**Your Ref: 2025/91185**

**10th July 2025**

**Building at Back Chapel Lane, Moldgreen, Huddersfield - (KIRK) Demolition of redundant engineering building and erection of student accommodation block**

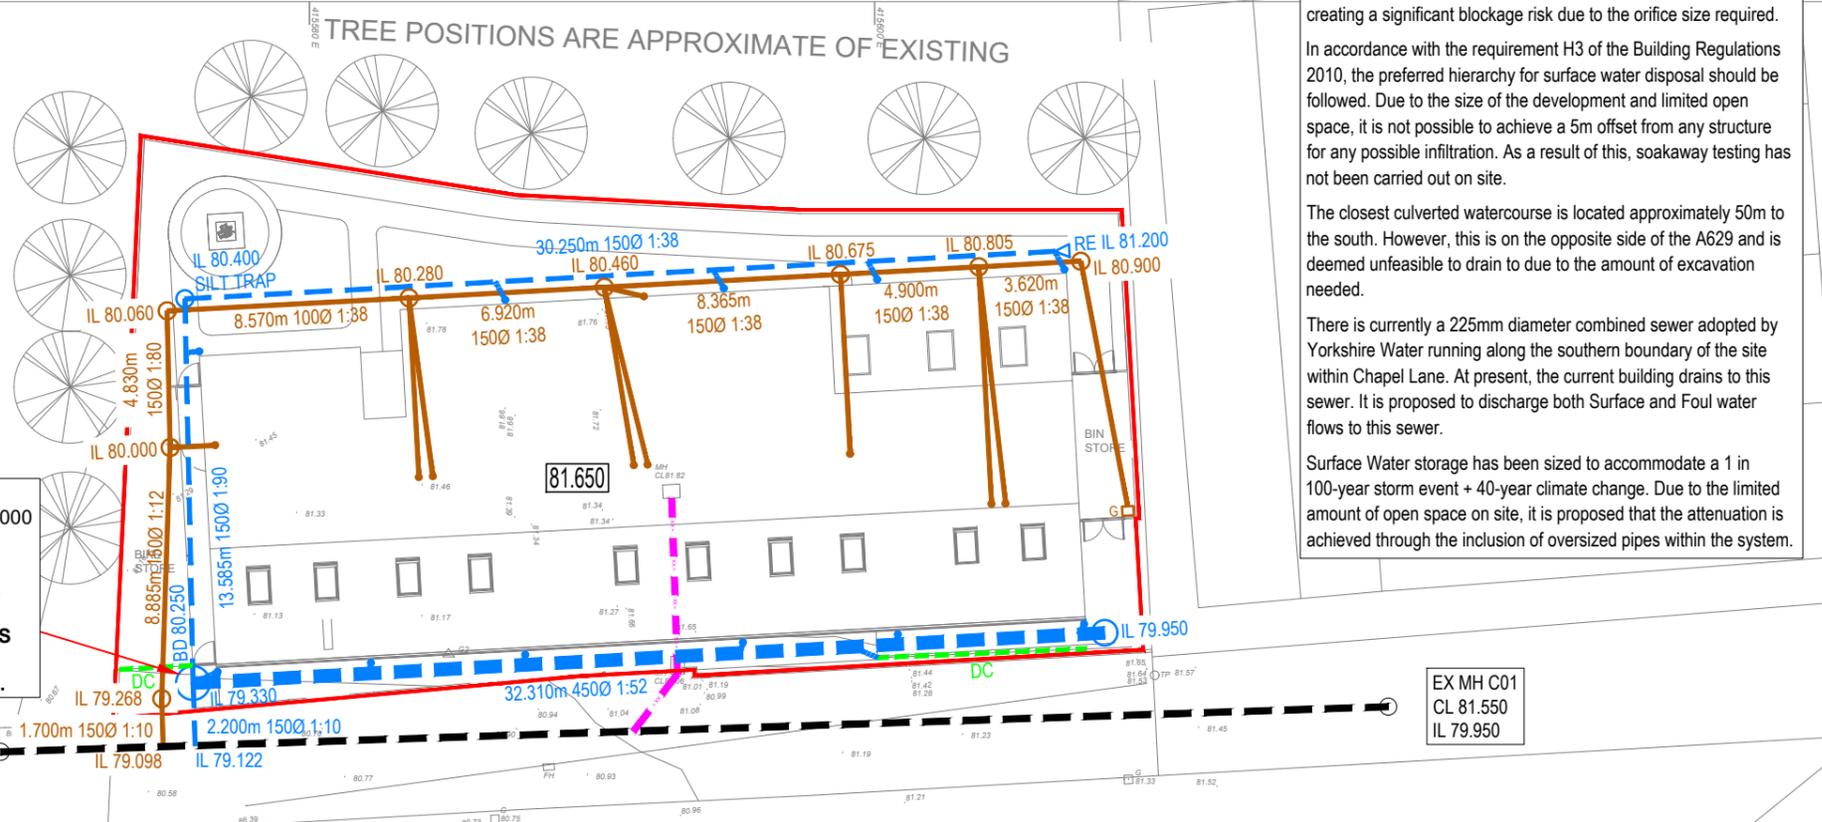
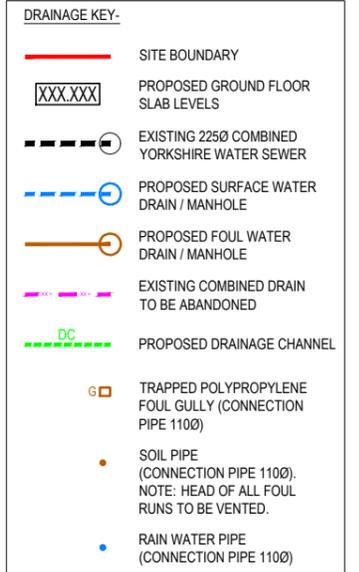
1) Yorkshire Water has no objection in principle to:

- a) The proposed separate systems of drainage on site and off site
- b) The proposed amount of curtilage surface water to be discharged to the public combined water sewer at a restricted rate of 3 (three) litres/second
- c) The proposed points of discharge of foul and surface water to the 225mm diameter combined public sewer in Chapel Lane

submitted on drawing P4540-01 (revision P01) dated 29/04/2025 that has been prepared by Avie Consulting Ltd.

**The development shall be carried out in accordance with the details shown on the submitted plan, P4540-01 (revision P01) dated 29/04/2025 that has been prepared by Avie Consulting Ltd, unless otherwise agreed in writing with the Local Planning Authority. (In the interest of satisfactory and sustainable drainage)**
